MMC: FW: Shaws TCP (CMP) - Status

Hi Nell – The following is a status update of previous comments based upon new information submitted by the applicant. Thanks

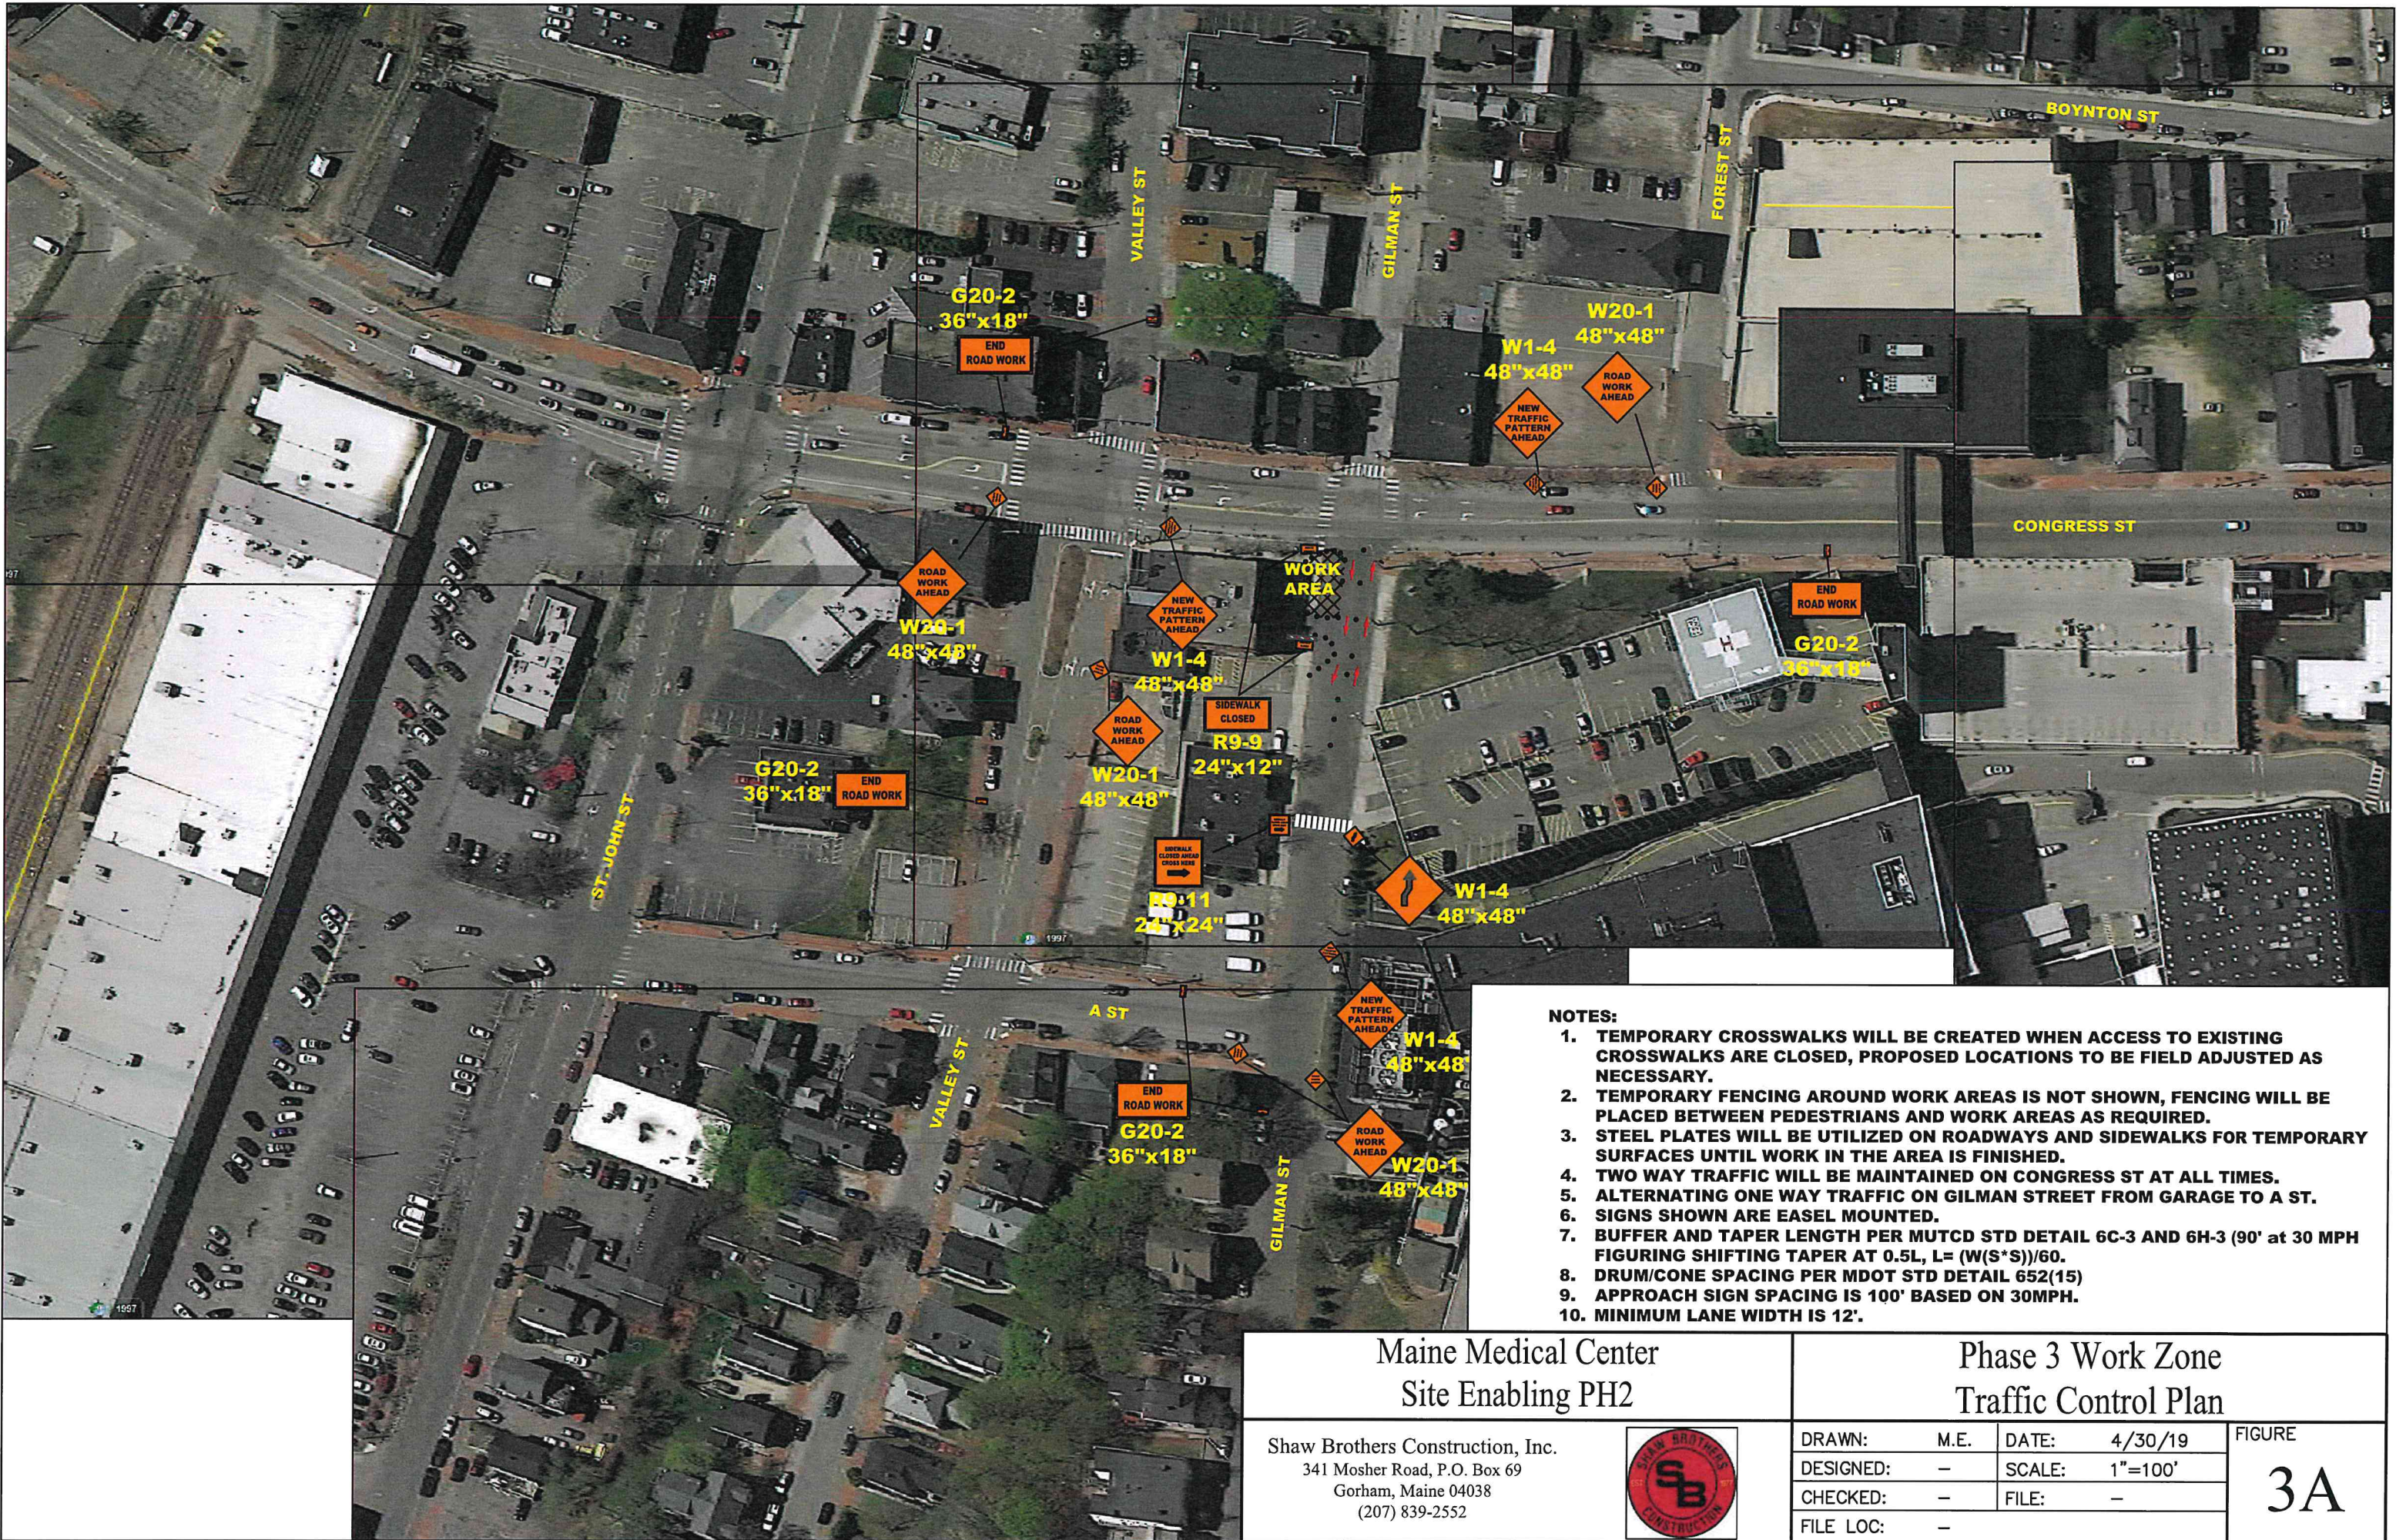
- I am concerned about pedestrians crossing on Congress Street west of Gilman, where multiple lanes and barrels are provided. Greater detail or adjustment is suggested. **Plan has been modified. This should be reviewed in the field and may need to be provided at Gilman if unsafe pedestrian routes occur.**
